OXFORDSHIRE COUNTY COUNCIL'S RESPONSE TO CONSULTATION ON THE FOLLOWING DEVELOPMENT PROPOSAL

Application no: 23/01633/F

Proposal: Demolition of existing retail units and public car park and redevelopment for residential dwellings (C3 Use), provision of private car parking, hard and soft landscaping and photovoltaic (PV) panels on roof, and associated works.

Location: Site at Calthorpe Street and Marlborough Road, Banbury

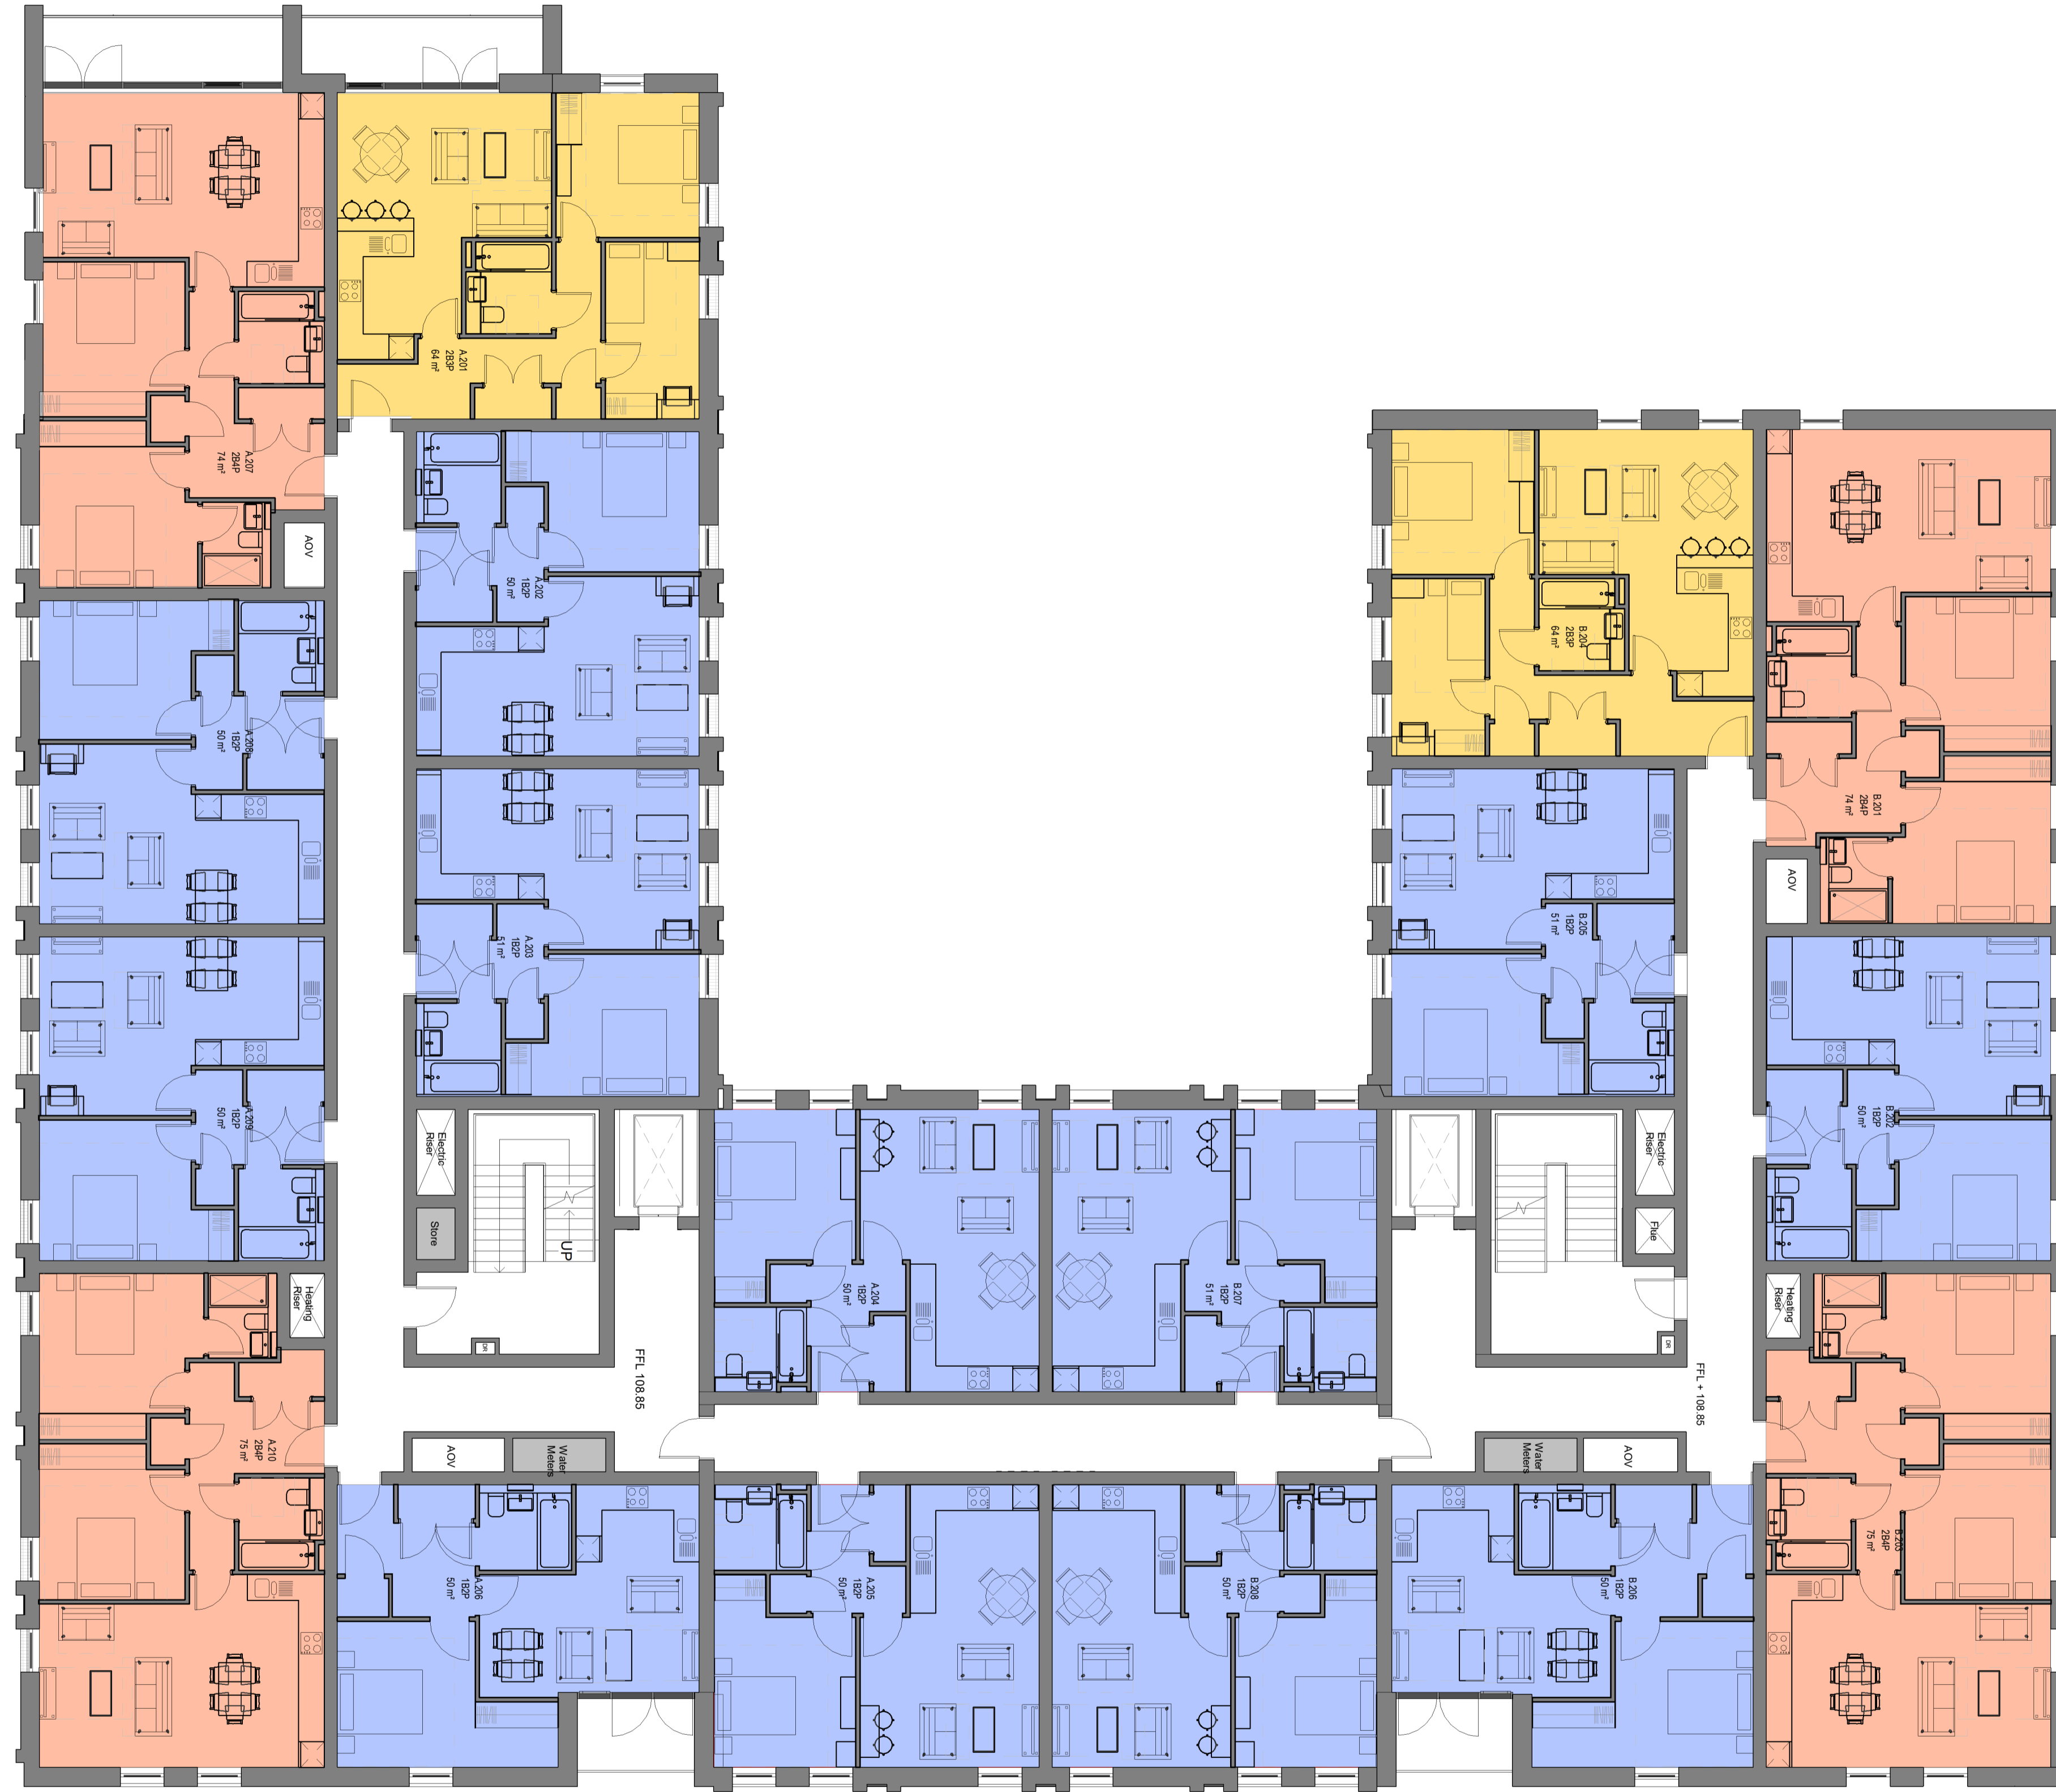
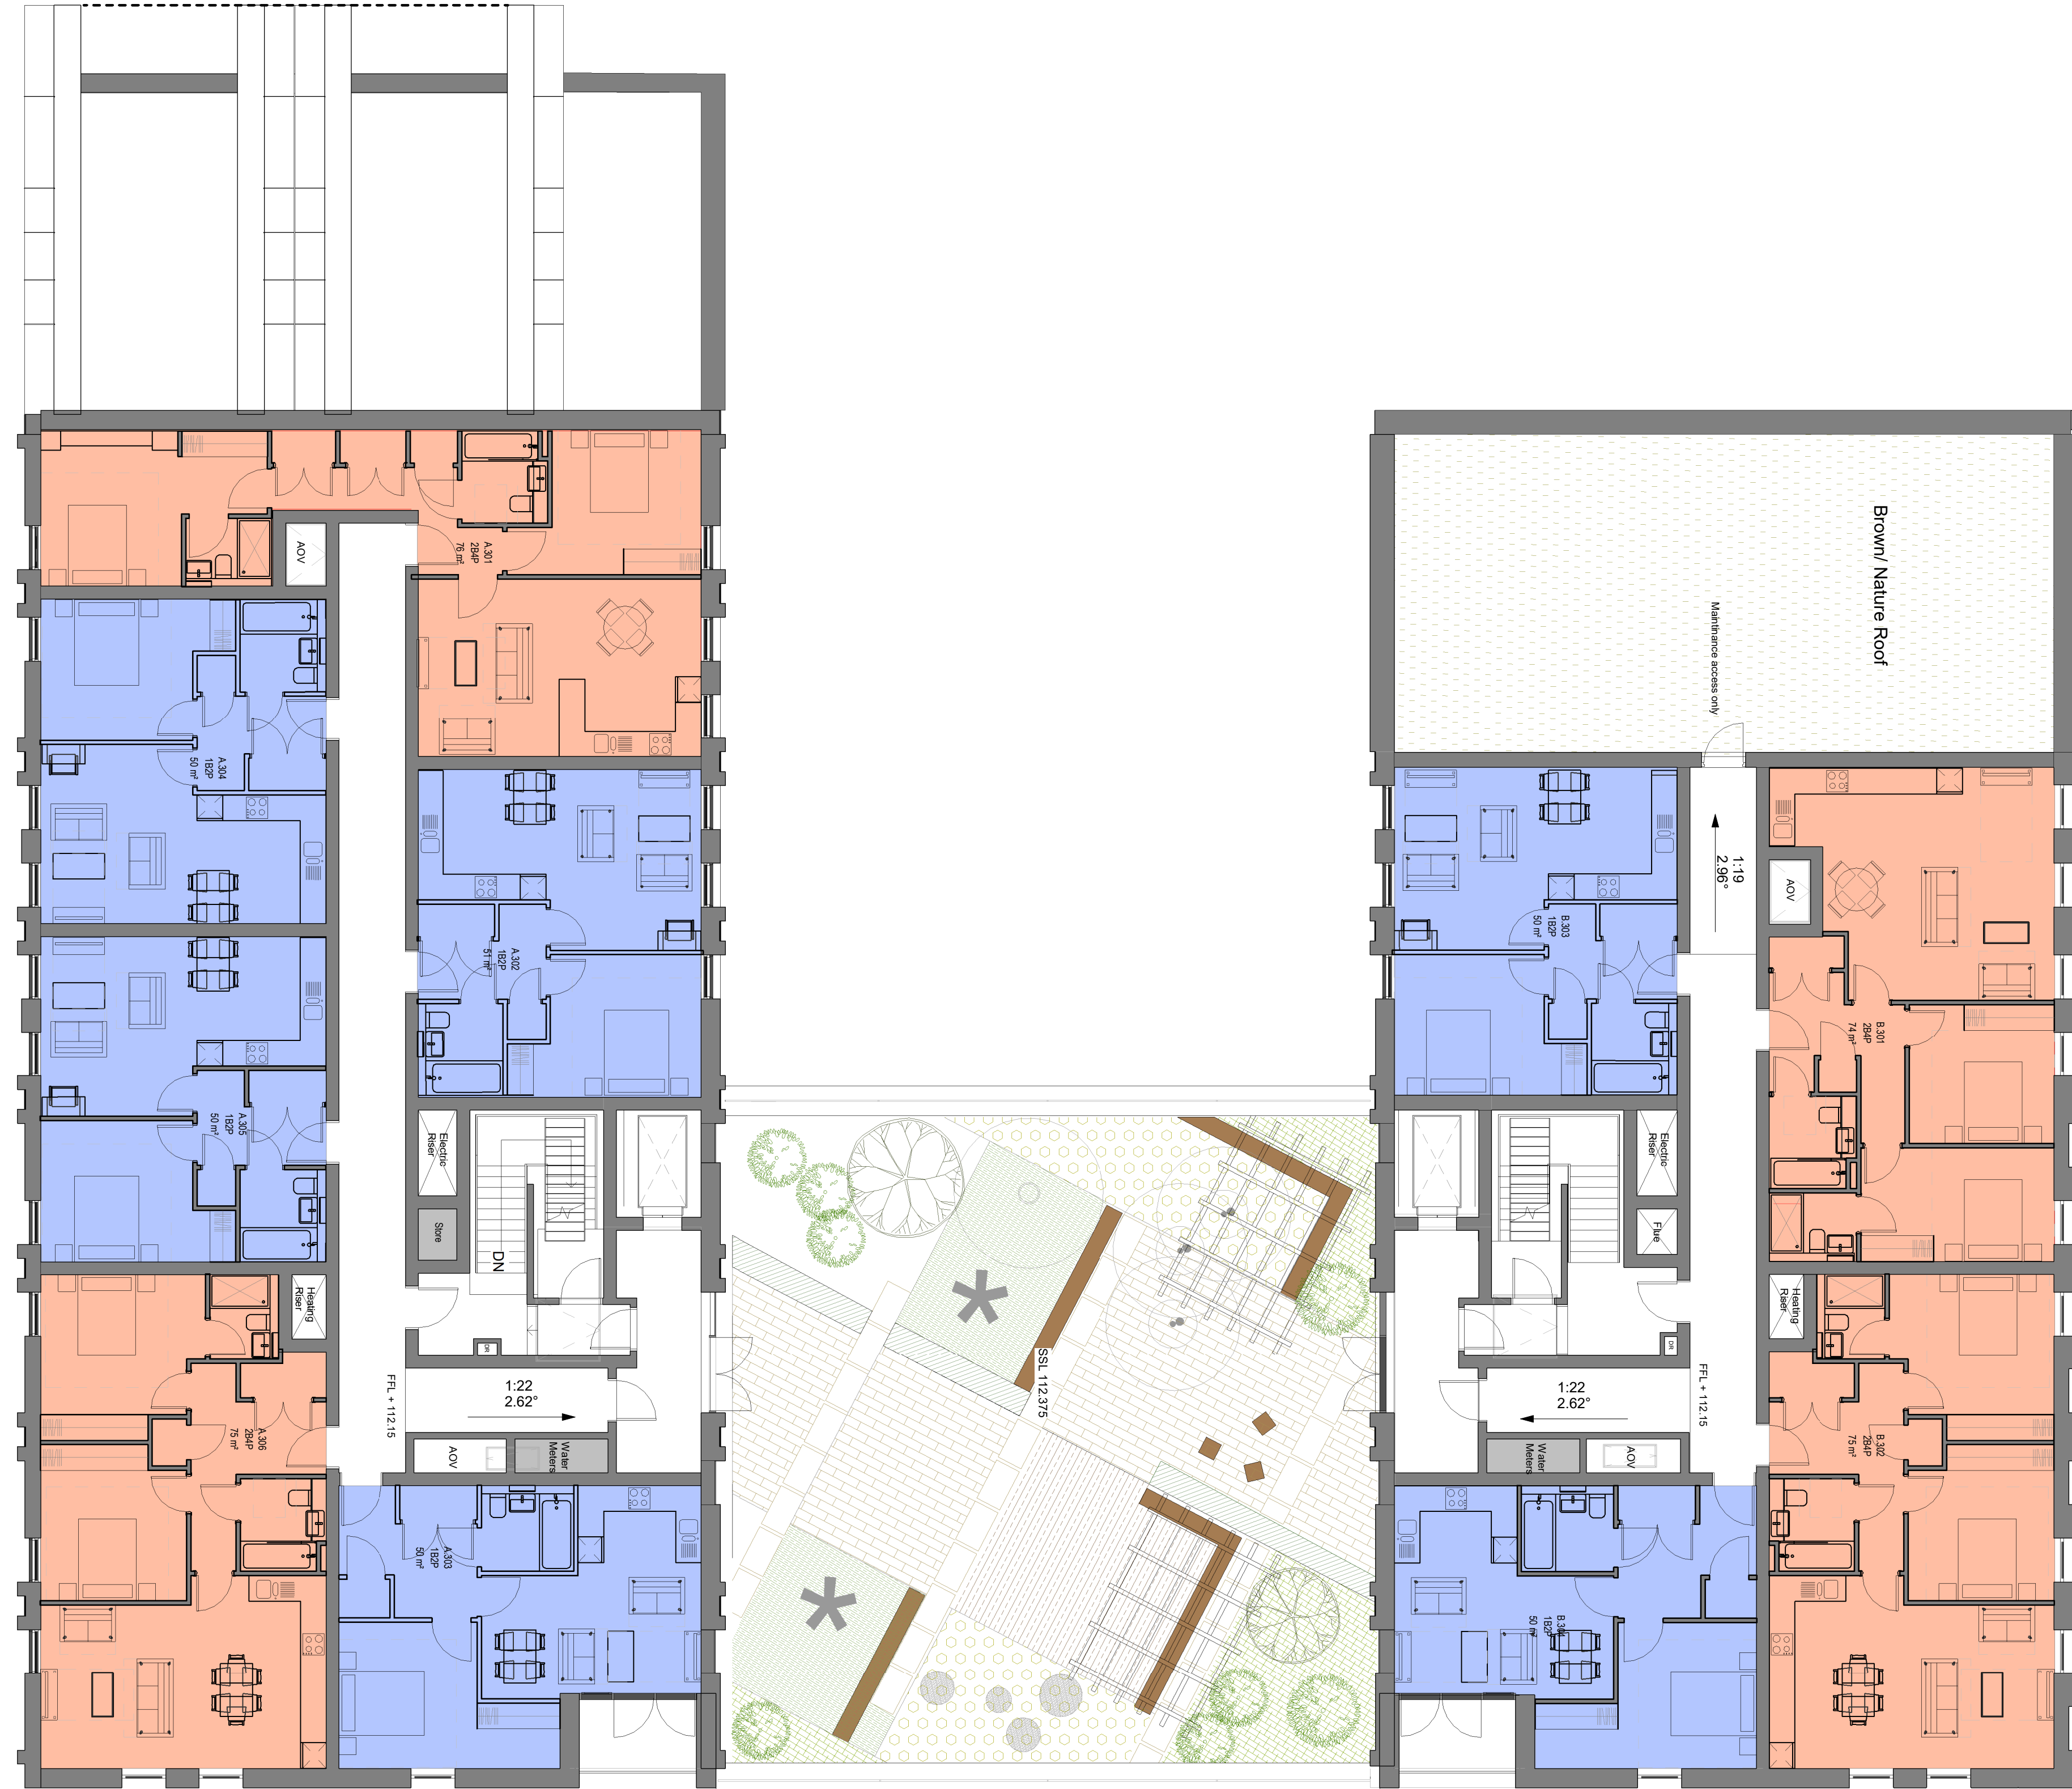
A number of cycle stores are provided throughout the site, although their location is not clear from the floor plans, on which they are not labelled. Further detail is required to understand exactly where these stores are, how they are accessed, and the type of cycle parking within them. The OCC Parking Standards state that cycle parking should be provided in a convenient location close to building entrances and that the parking should be in the style of a Sheffield stand, not double-decked or vertical unless agreed by OCC in special circumstances. **Further information required.**

Refuse collection would be from within the development, however bin stores are not labelled on the floor plans. **Further information required.**

Figure 4-4 Cycling Catchment

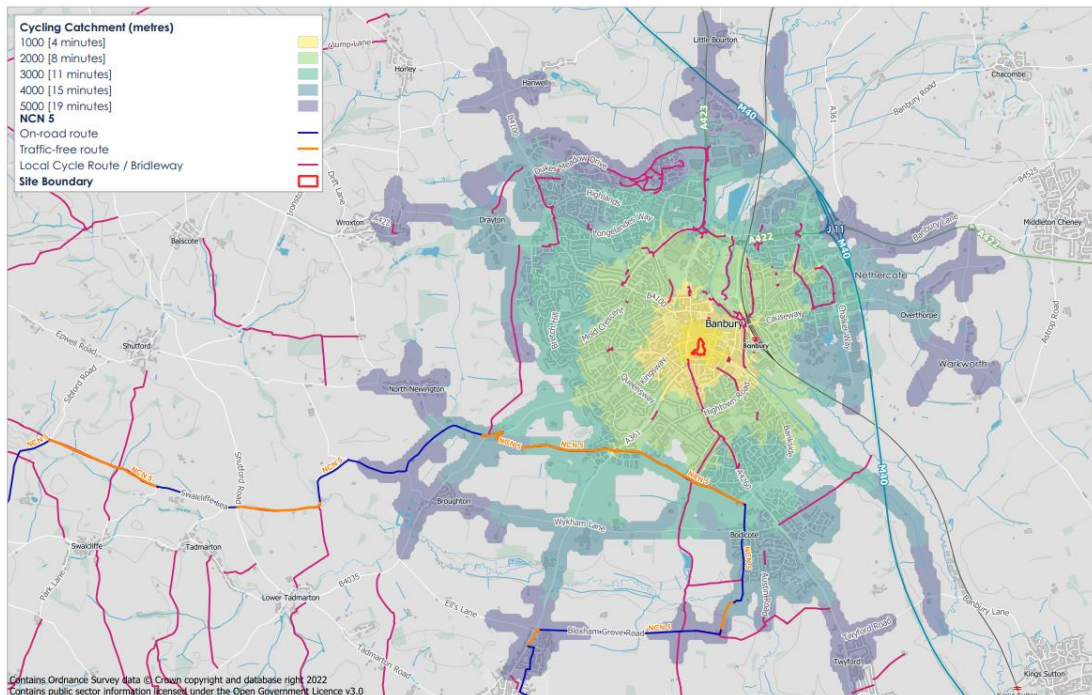
Although the site is located within easy cycling distance of employment and facilities, cycling connectivity across the town centre is currently poor. I am not sure whether the cycling times shown in the transport assessment take account of this. It is not possible for cyclists to turn right onto Marlborough Road. They can turn left and then right onto the high street but would then need to turn right into George Street, i.e. they are not permitted in the pedestrianised part of High Street. To access employment to the north of the town they would need to use South Bar and North Bar.
